DEVELOPMENT REVIEW BOARD  
TRANSPORTATION DEVELOPMENT

DRB Project Number: 2018-001579  
Hotel at Winrock Mall

SUBJECT: Plat, Site Plan

DATE: January 8, 2020

City Project No. XXXX.XX Zone Map No. J-19 Sheet C1.3 Of SHEET

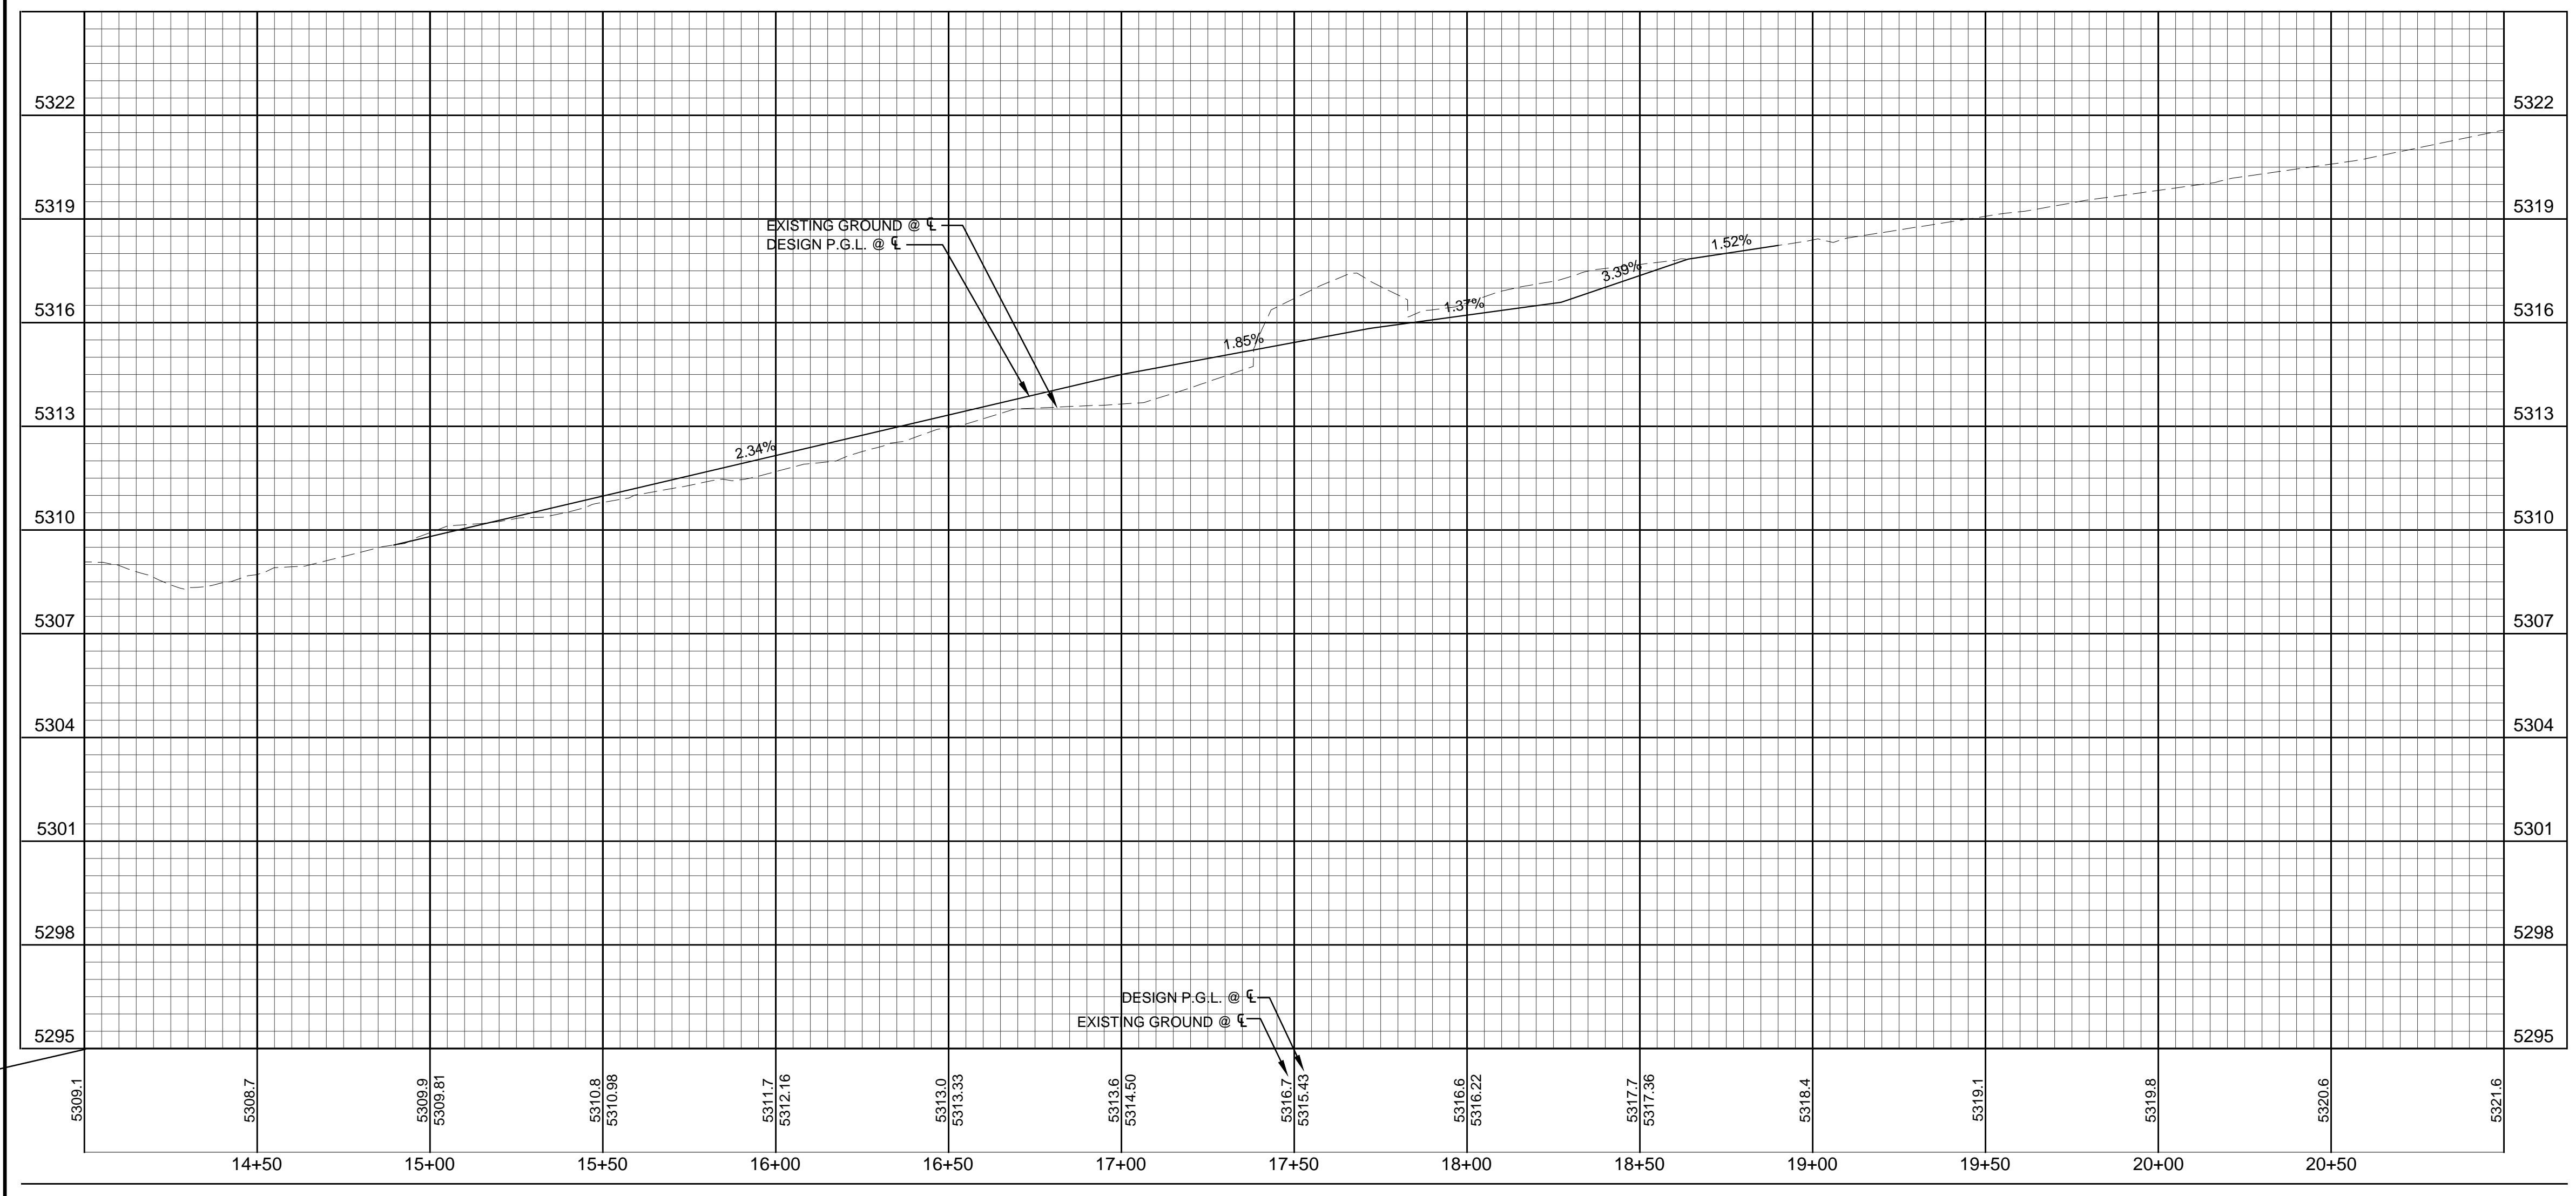
9. Change title of the profile for Sheet C1.3 to "Private Road 2 Plan and Profile".
10. C1.3 shows the proposed centerline profile above existing profile grade. (Show where tying into existing pavement on the plan view of the profile for smooth transitioning.)
